88 Preble Street: Corner of Alder/Lancaster

88 Preble Street: Corner of Preble/Lancaster

2 BITUMINOUS DRIVEWAY APRON DETAIL
C401 NOT TO SCALE

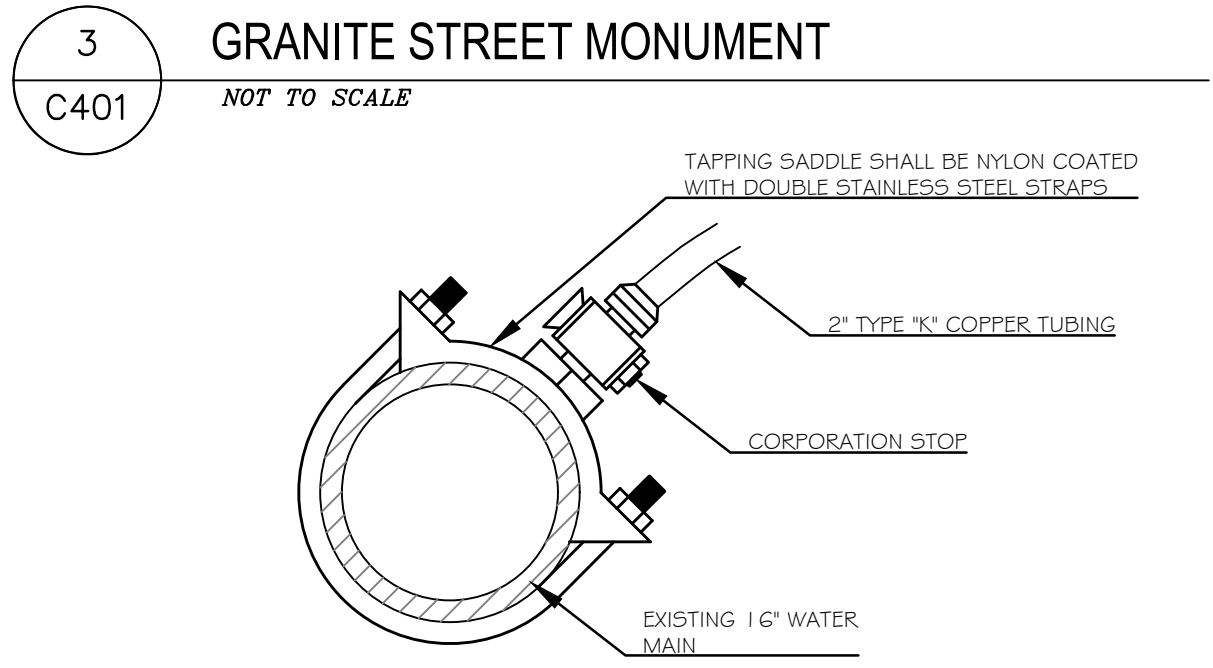
Maintain max. cross-slope across driveway for min. 4.5' - 5' of width; likely no need to ramp down entire width of sidewalk
